Application No: FG/89/22/HH
Site Address: 4 East Mead Ferring BN12 5EA
Description of works: Single storey rear extension.

Thank you for your internet representation made on 18th June 2022 which has been recorded as an objection with the comments as follows:

Client	MR ELIJAH JOSHUA PARAZO		
Project	PROPOSED REAR EXTENSION 4 EAST MEAD FERRING WEST SUSSEX BN12 5EA		
Drawing	PROPOSED GROUND FLOOR PLAN & ELEVATIONS		
Scale	Date	Drawn	
1:50 & 1:100 @ A1	17.05.22	TP	
Drawing No.	Revision

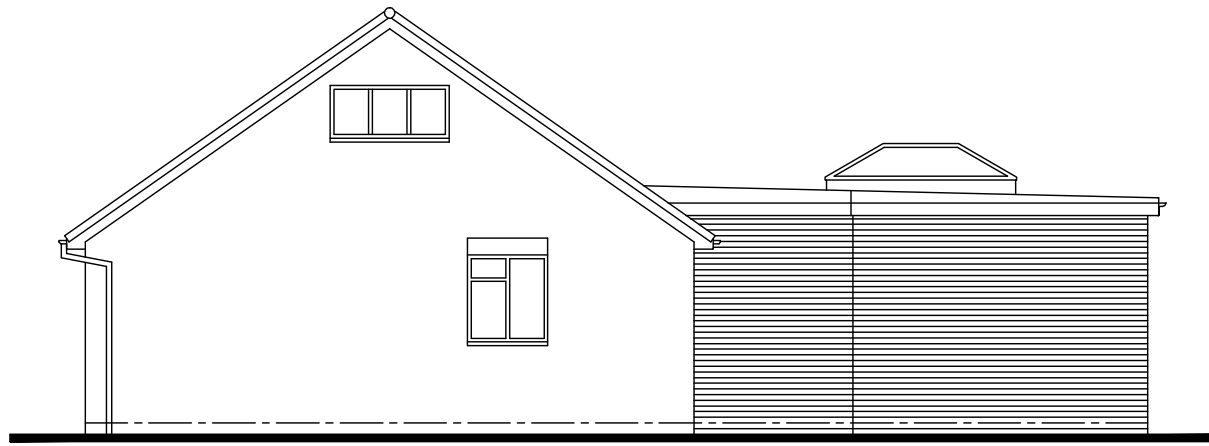
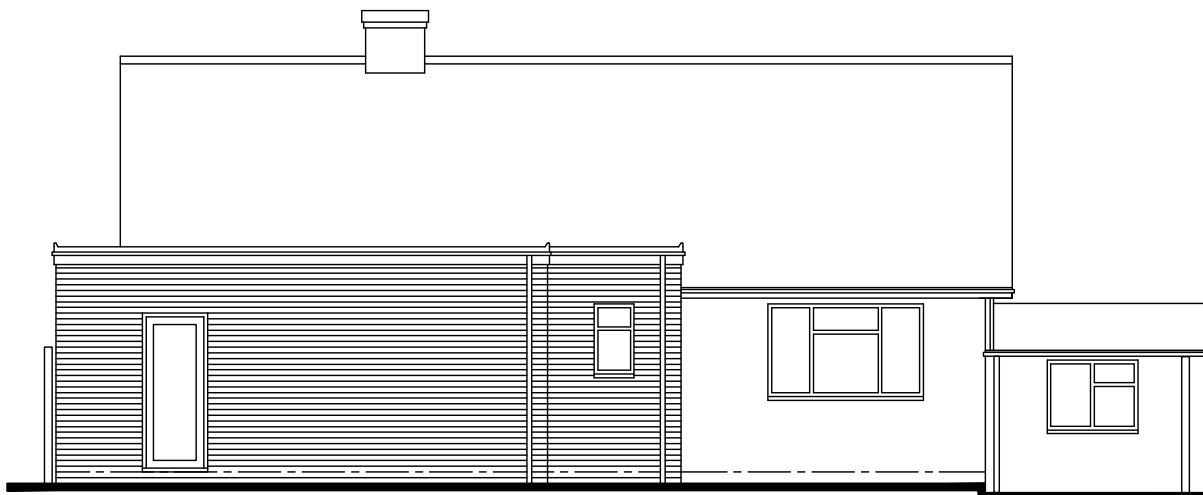
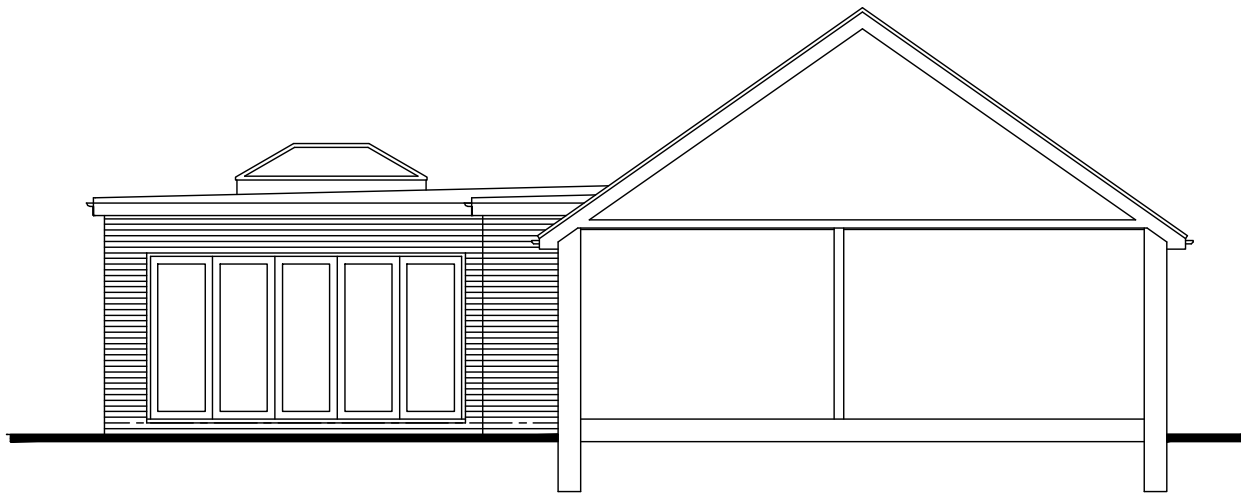
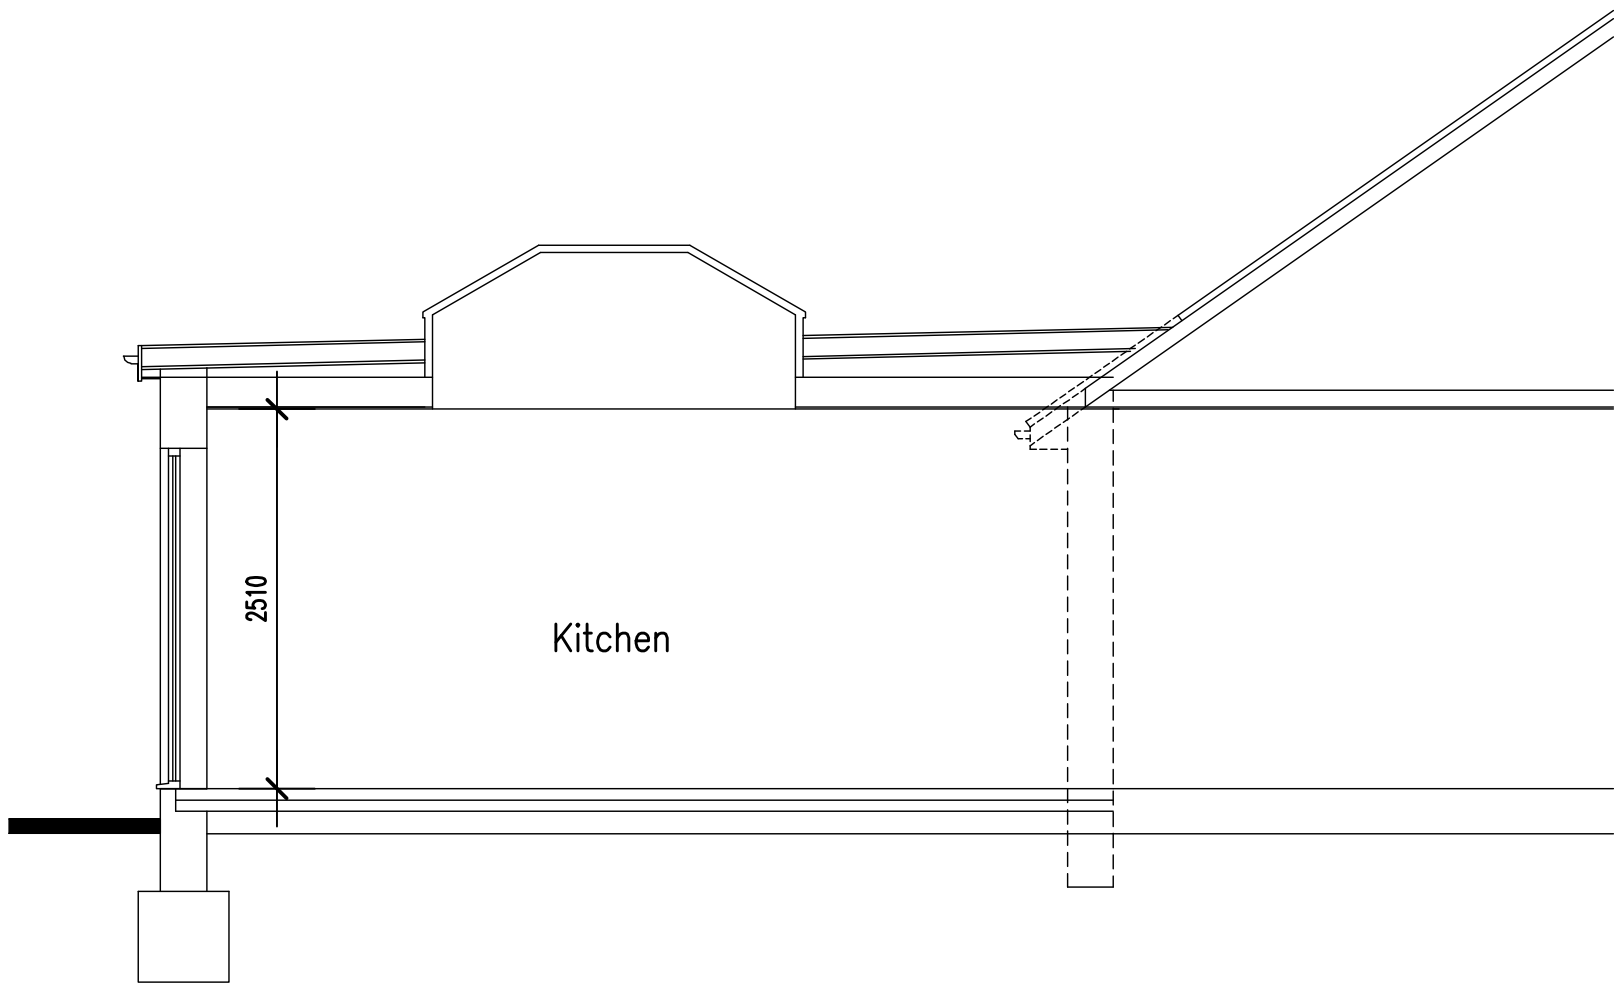
Is this extension going to affect our boundary line and afternoon daylight ? Is this a dwarf roof or a flat roof ? .
